Additional Responses to Change Application – Boston Borough Council

Our ref no: B/22/0271

Targeted Consult on changed to DCO to BBC for the proposed Heckington Fen Solar Energy Park.

Drawing file: EN010123 / EN010123-000554-6.3.8.12 - Appendix 8.12 - Biodiversity Net Gain Calculation - Rev 2.pdf

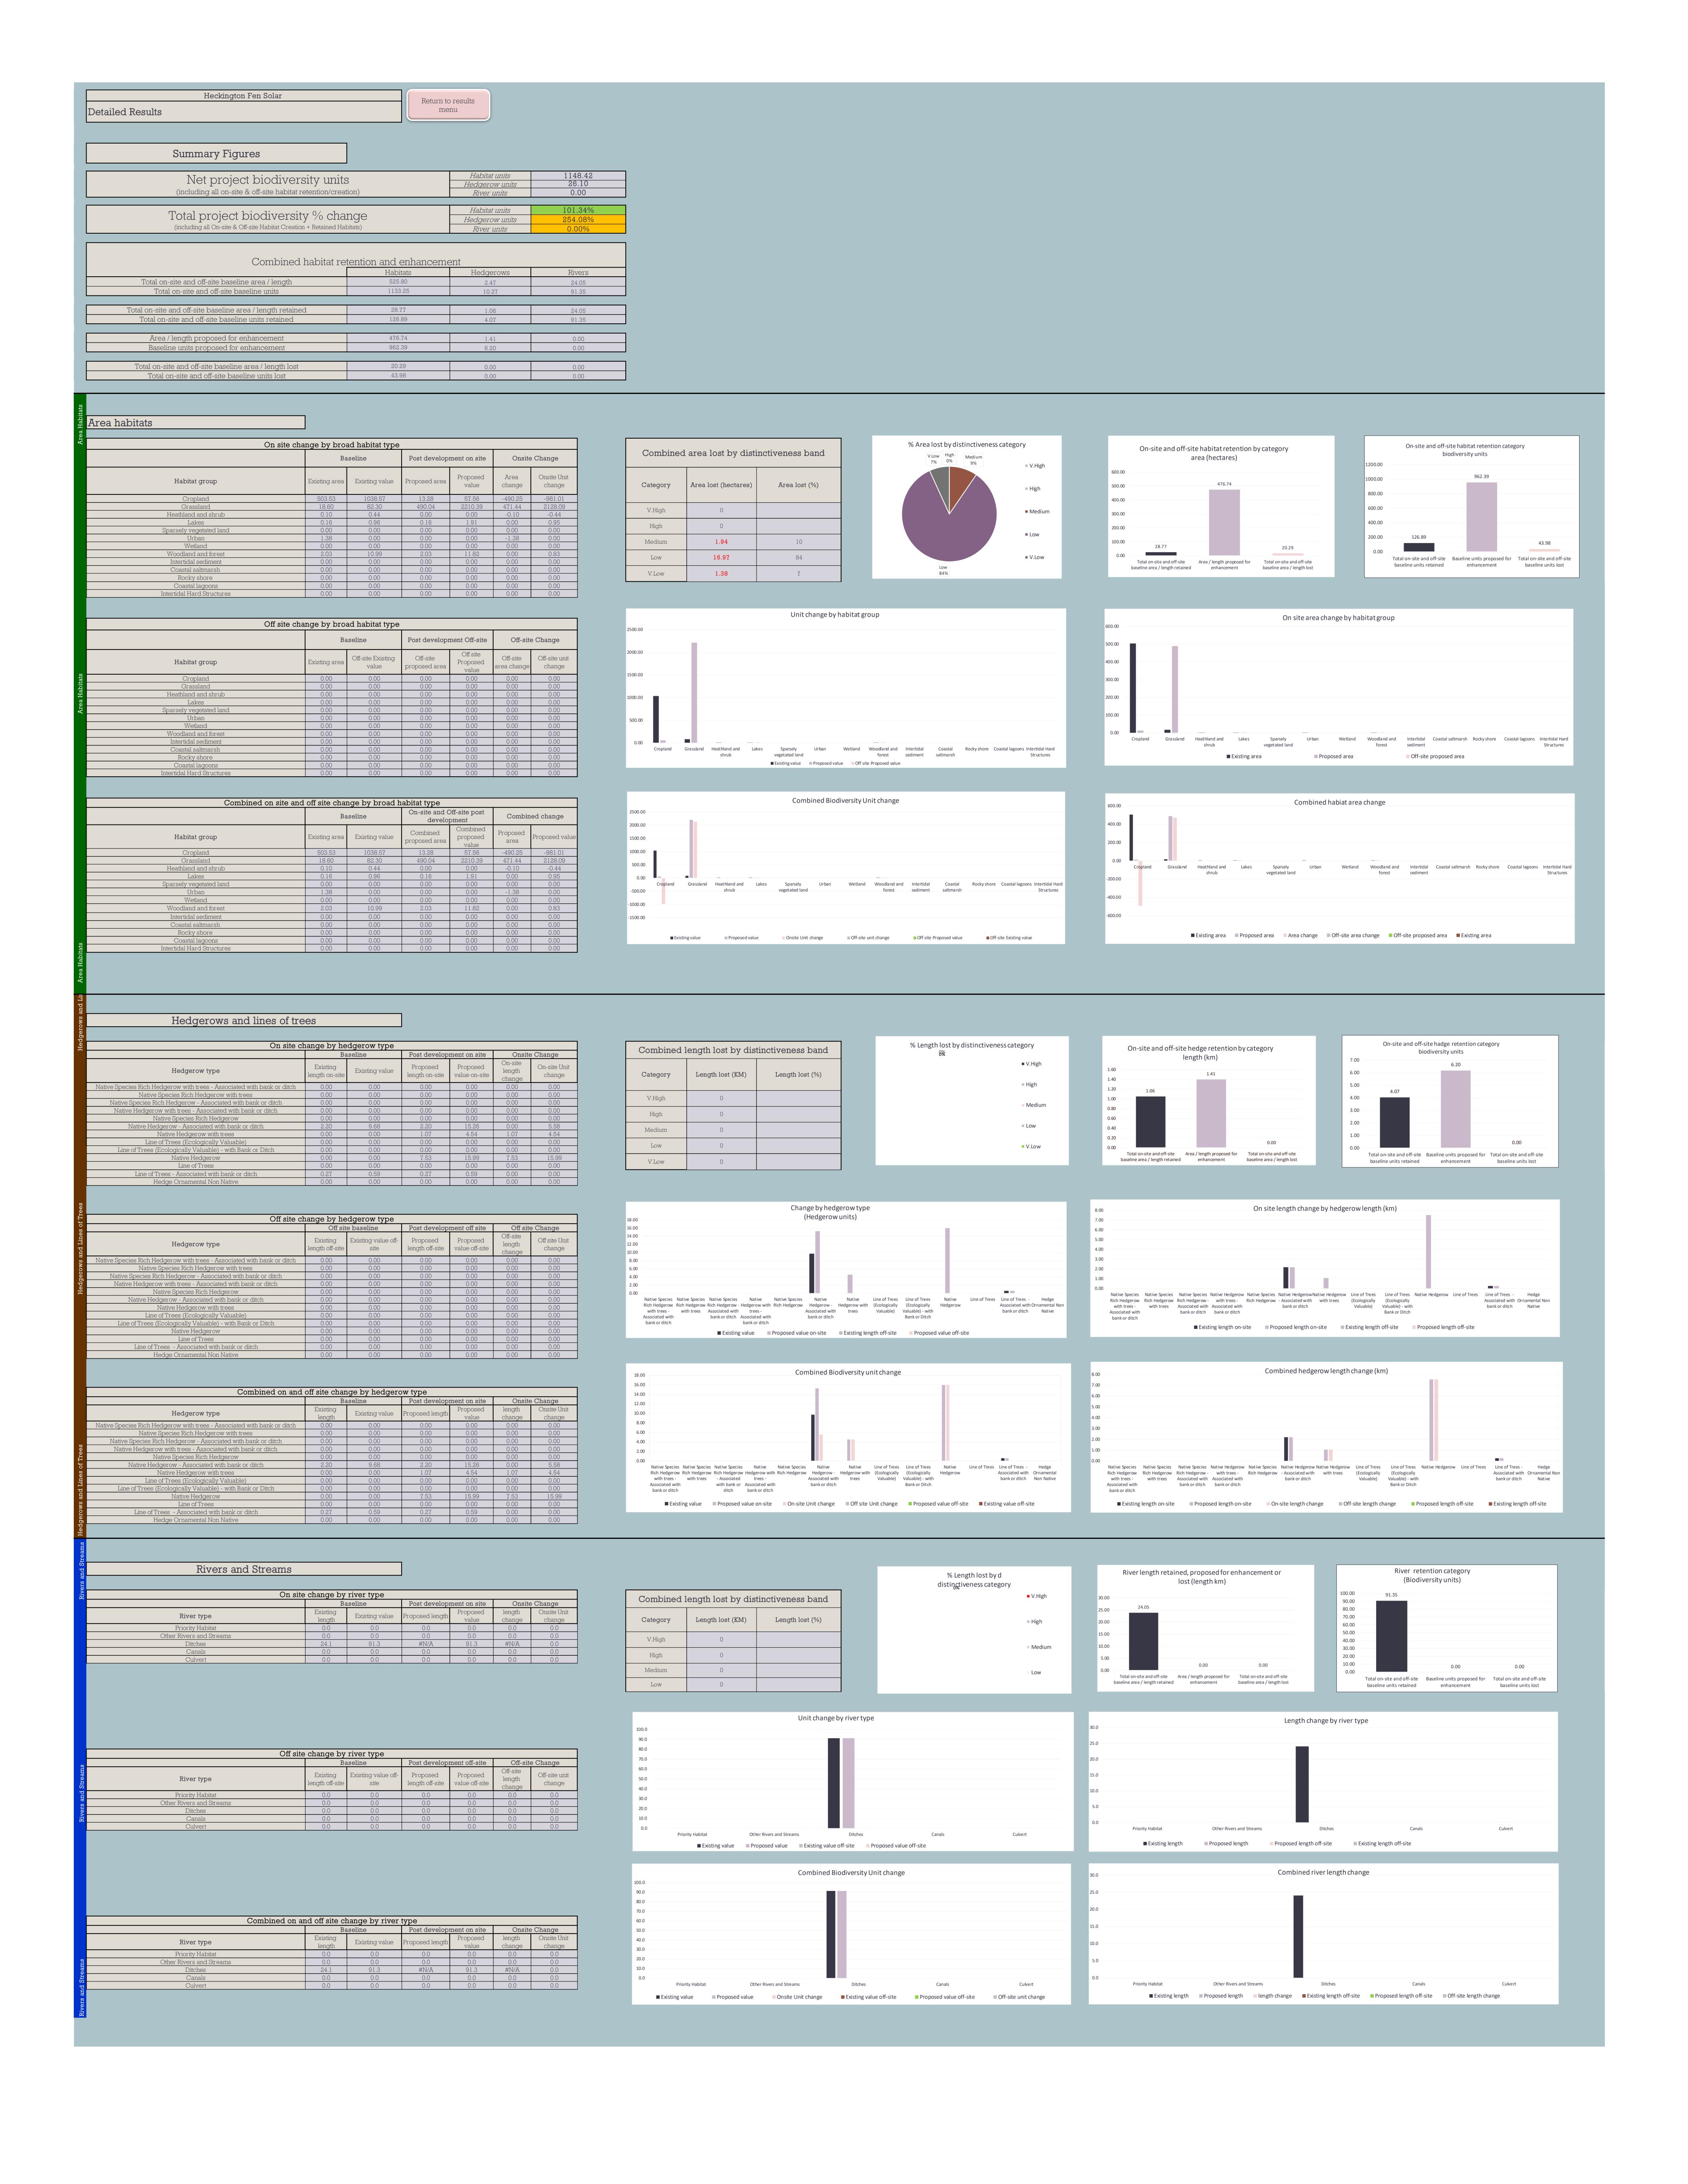
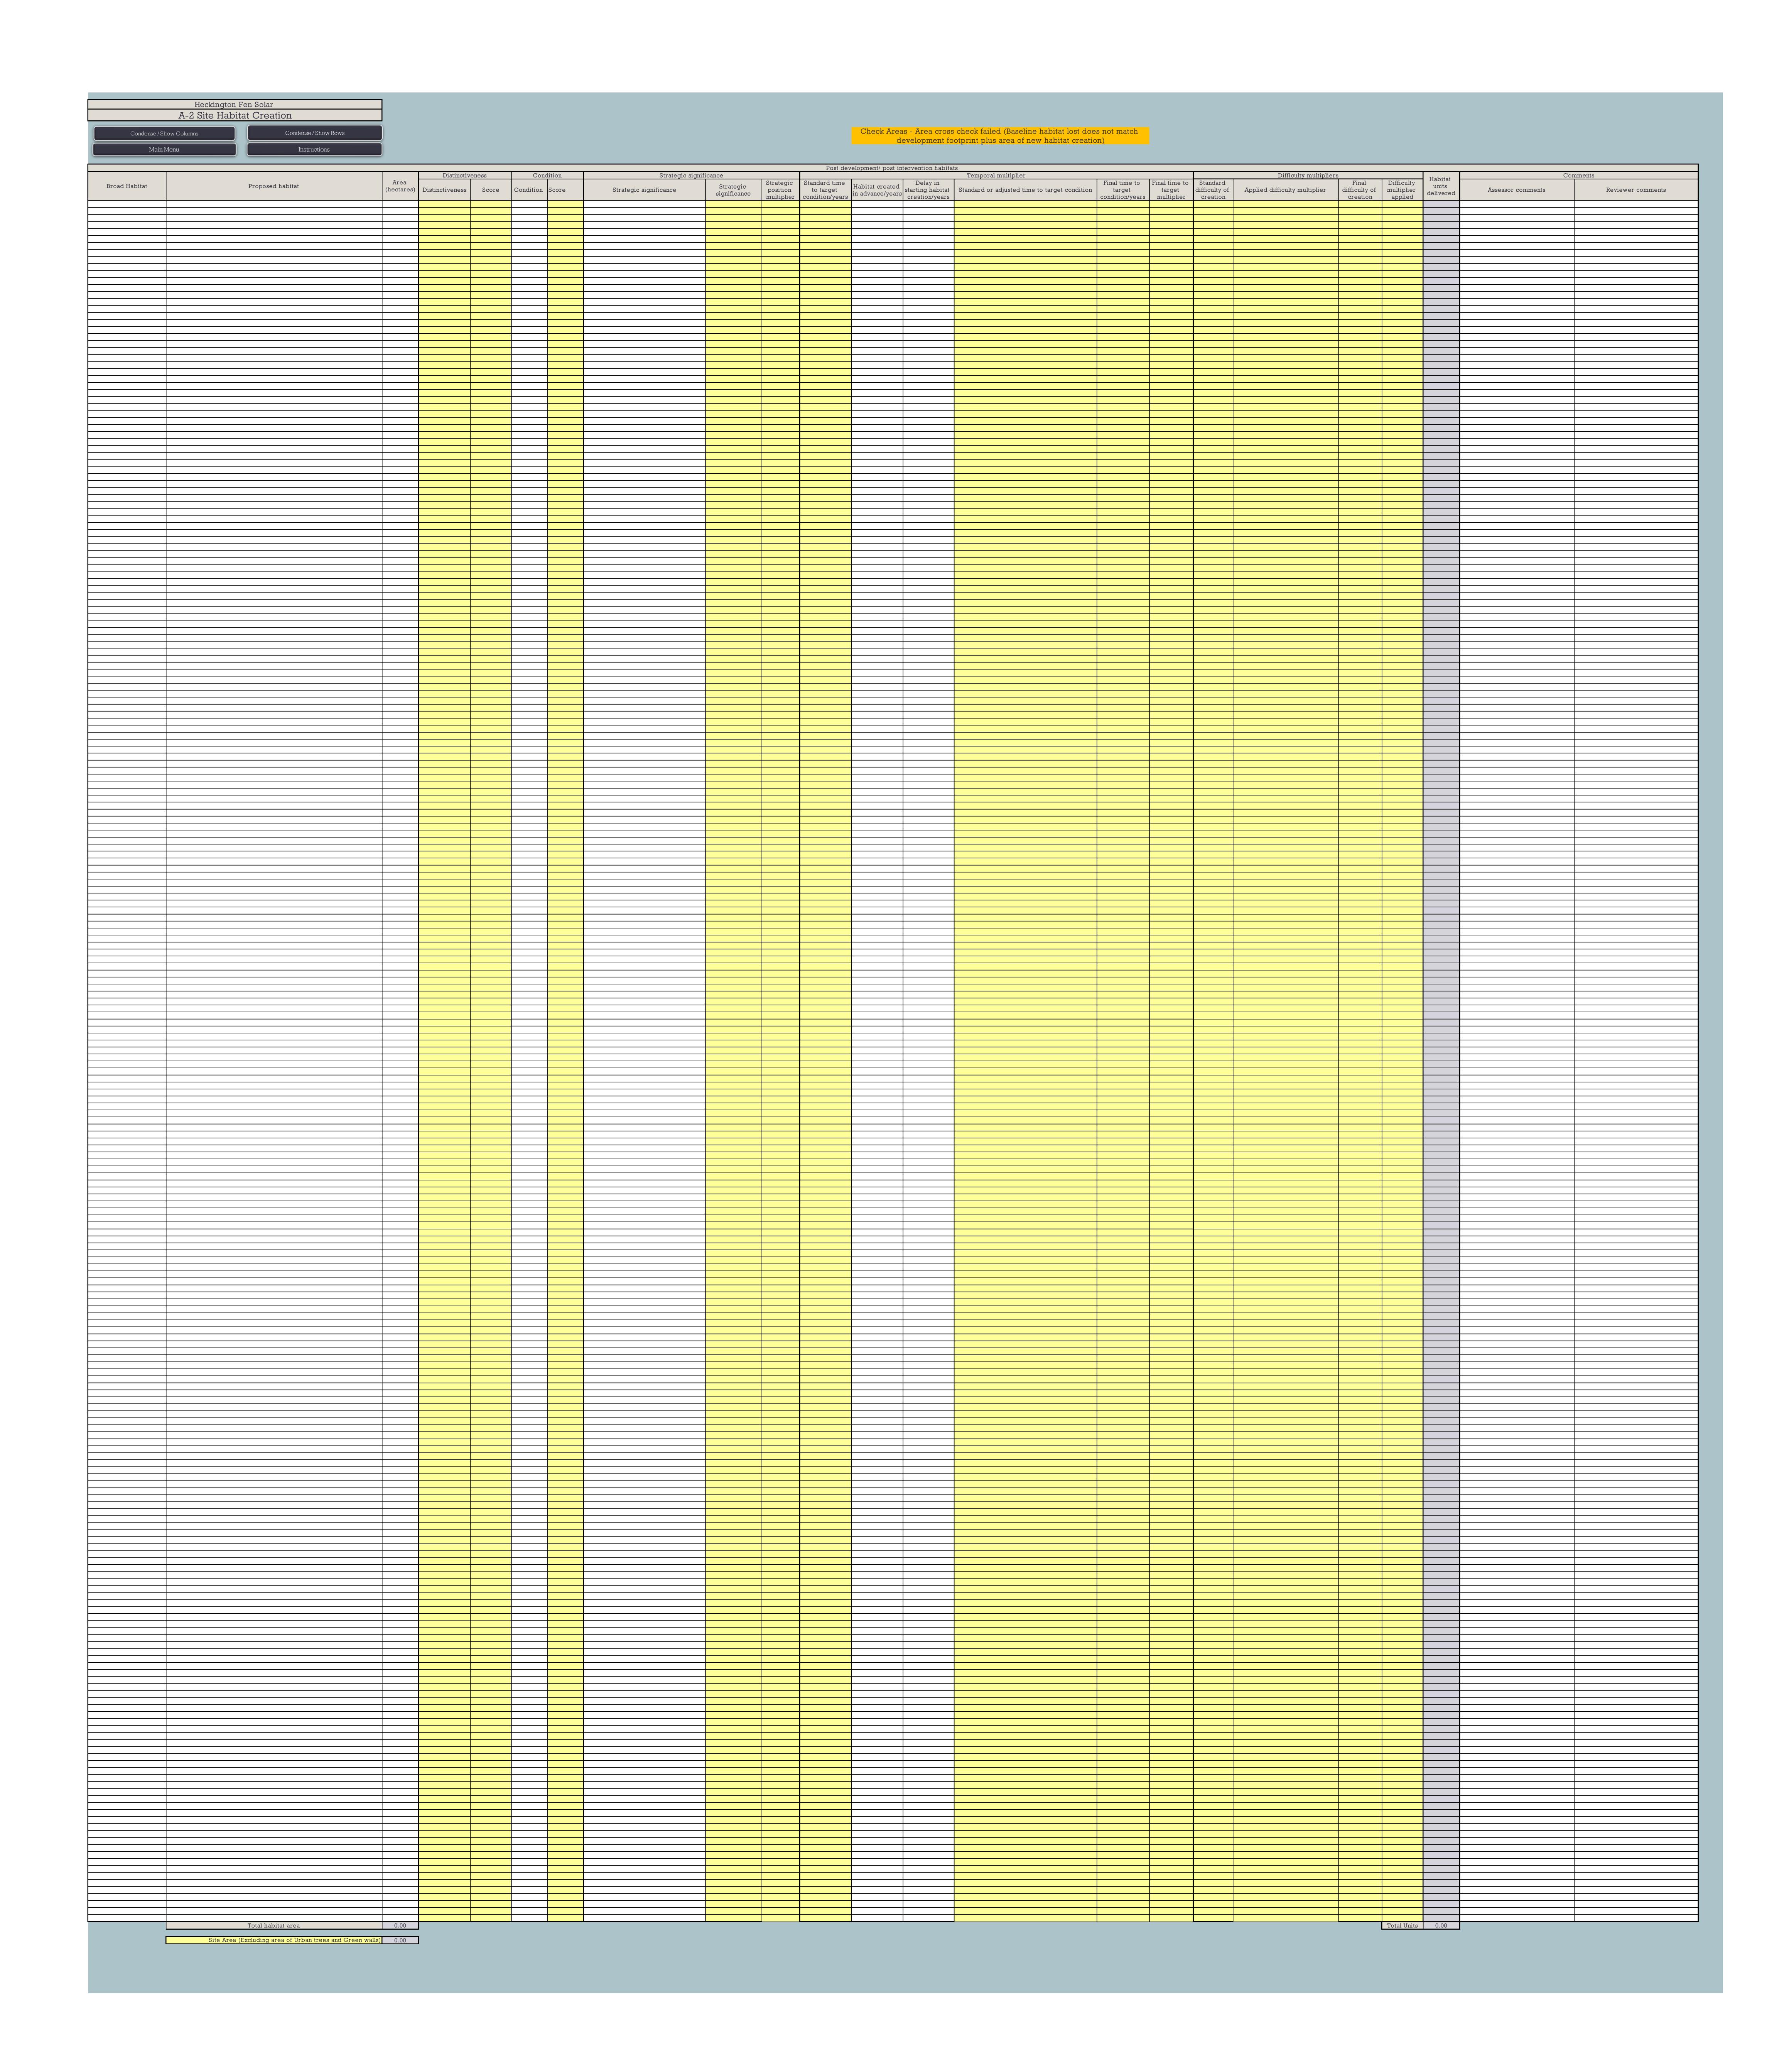
The submitted documents on the PINS web site include a BNG calculation but the contents are blank. NSIPS will be required to produce 10% uplift from 2025. Given what is suggested on the solar park itself there could be an opportunity to show a 10% net gain despite the felling of these trees.

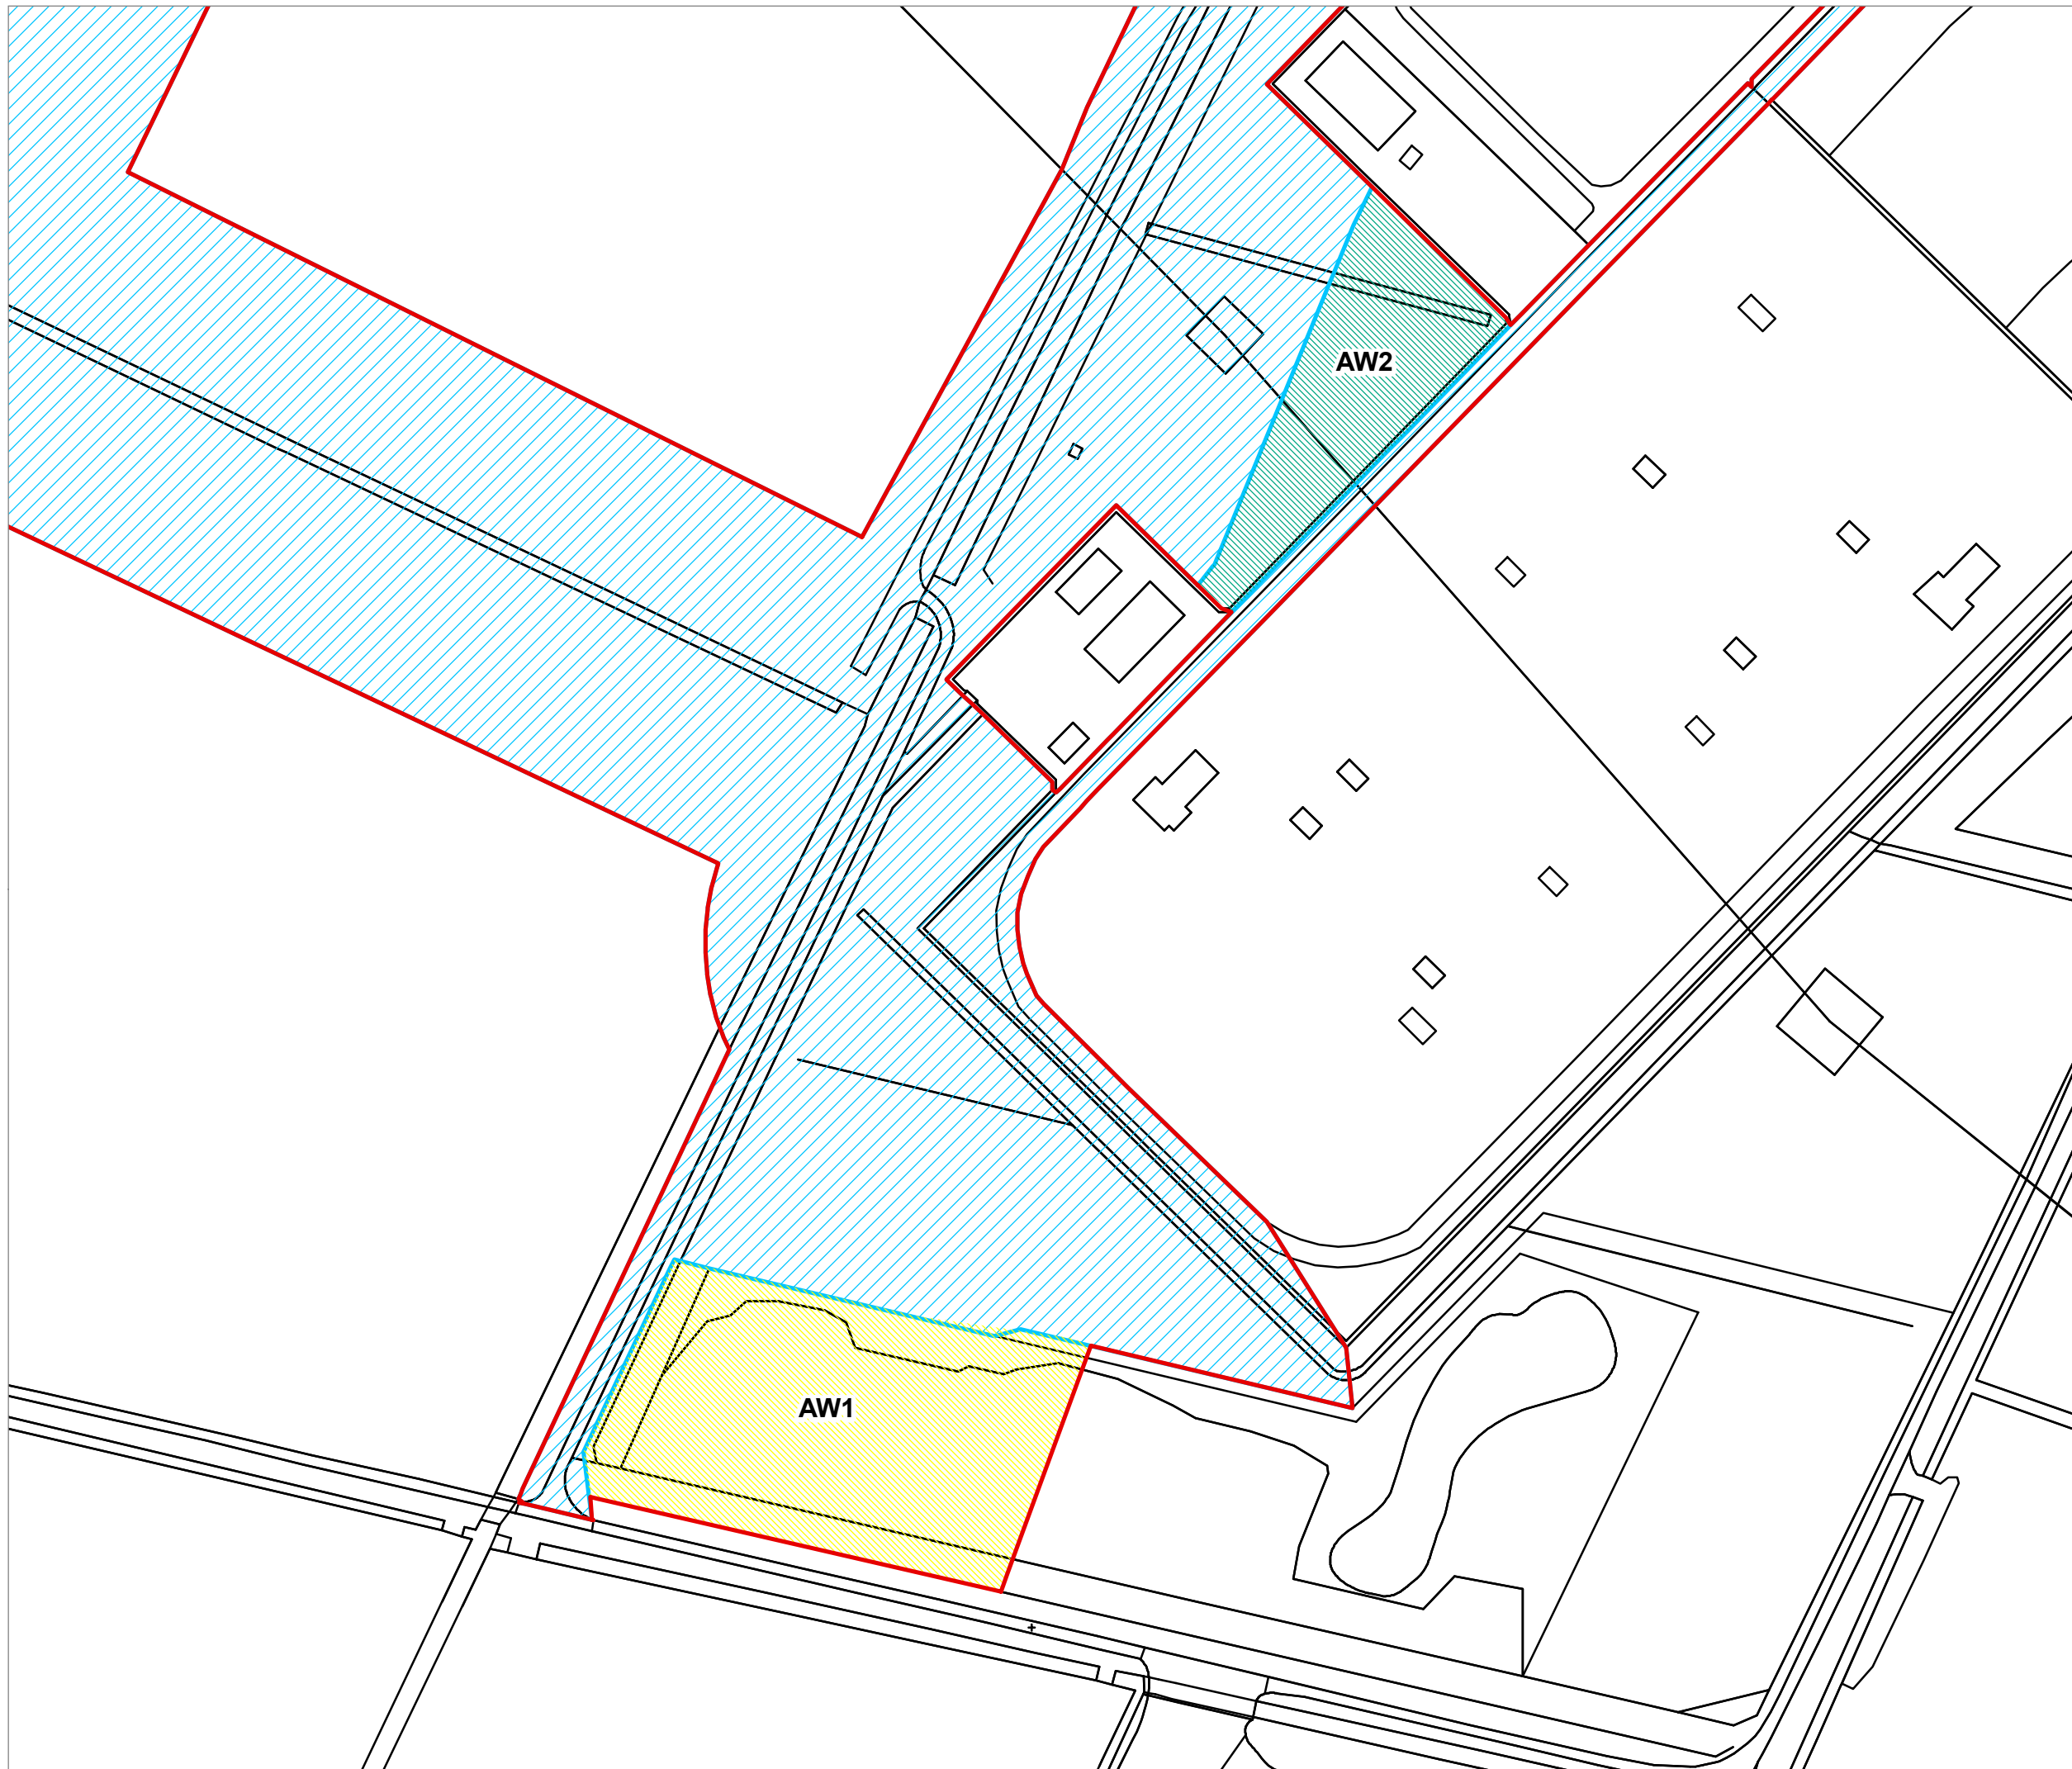
One area labelled AW2 is screened by the existing substation and Boston Borough Council have no objections to it.

The other area labelled AW1 requires the removal of trees that were planted when the substation was constructed in order to screen it which is disappointing. They are on the southern boundary and so visual impact is lessened by the fact that few people will venture here as it is very remote.

The amount of trees to be removed depends on what type of infrastructure is used. One type (Air insulated) requires a large amount, the other (Gas insulated) requires less and would be in a building. A row of oak trees on the frontage are to remain.

Therefore, Boston Borough Council would prefer the gas insulated option so fewer trees are felled and those that are felled are replanted on the substation to repair the localised harm.
